From: Derbyshire, Ryan <Ryan.Derbyshire@lancashire.gov.uk>
Sent: 23 March 2022 09:53
To: Nicola Hopkins <Nicola.Hopkins@ribblevalley.gov.uk>
Cc: LHS Customer Service <lhscustomerservice@lancashire.gov.uk>; Holt, Kelly <Kelly.Holt@lancashire.gov.uk>
Subject: RE: 3/2020/0911-Shackletons Garden Centre Ltd Clitheroe Road Chatburn BB7 4JY

Subject: 3/2020/0911-Shackletons Garden Centre Ltd Clitheroe Road Chatburn BB7 4JY

proposed car park layout 1/2

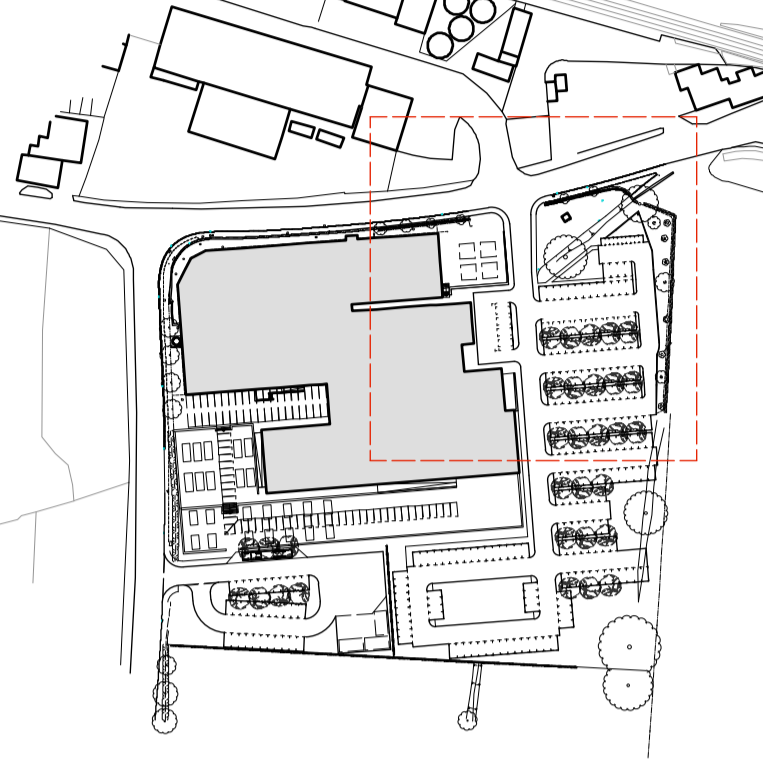
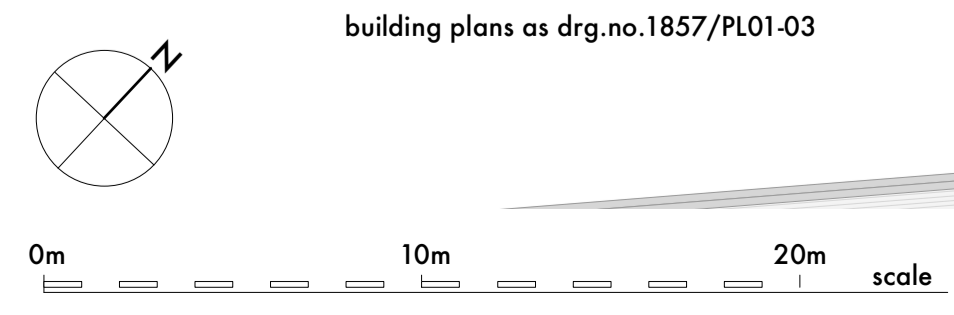
Instead can the drainage condition below replace the one I have sent on the highway observations.

The drainage condition is-

"The surface water from the approved car park should be collected within the site and drained to a suitable internal outfall. Prior to commencement of the development details of the drainage strategy shall be submitted to and approved in writing by the Local Planning Authority. The scheme shall be implemented in accordance with the approved details.

Reason: In the interest of highway safety to prevent water from discharging onto the public highway."

Condition 11 is somewhat confusing in that it refers to the 'highway surface water drainage scheme'. The Highway is beyond our site boundary and the responsibility of LCC. If it means 'surface water drainage scheme insofar as it affects discharge to the Public Highway', then we've addressed this in the Drainage Strategy. It would require a detailed drainage design to be approved pre-commencement, ensuring no water discharges onto the highway.
